DECISION DELEGATED TO HEAD OF PLANNING

Application No: H03-0104-26 **Applicant:** Mr G Mason
Proposal: Erection of two holiday lodges
Location: Land Adj Poplar Kennels Poplar Farm Banks Drove
Terminal Date: 3rd April 2026

Front Elevation

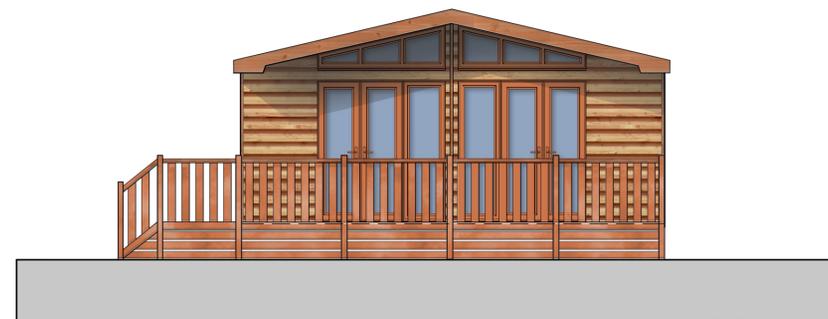
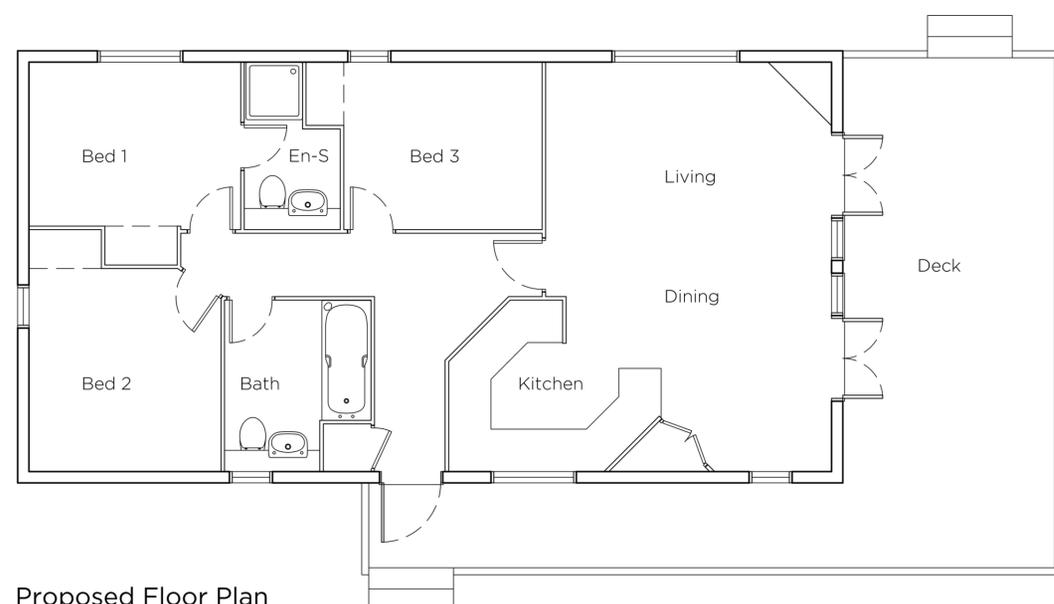
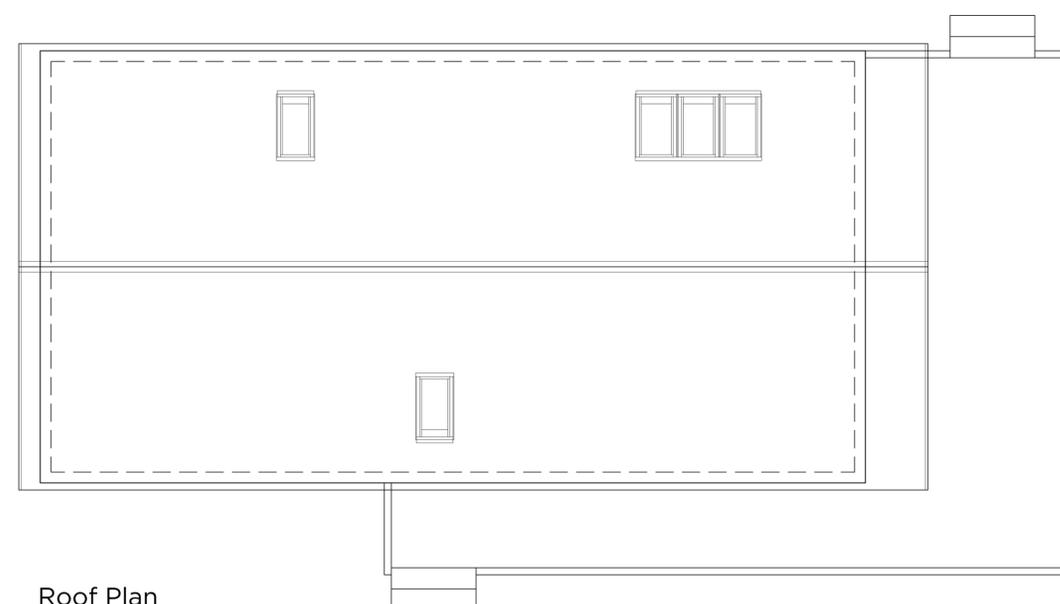
The proposed buildings are typical of tourism enterprises. The design is generic, as are the materials. There is nothing within the design which would necessarily relate to the surrounding built form or the vernacular of the area. The development would therefore appear placeless.

Fundamentally, the proposal would represent the expansion of built form into a rural area. This built form is not itself inherently rural or rooted in a sense of place. The proposal can therefore be considered as unwarranted expansion of built form into a rural area, which would be detrimental to the existing character of the area.
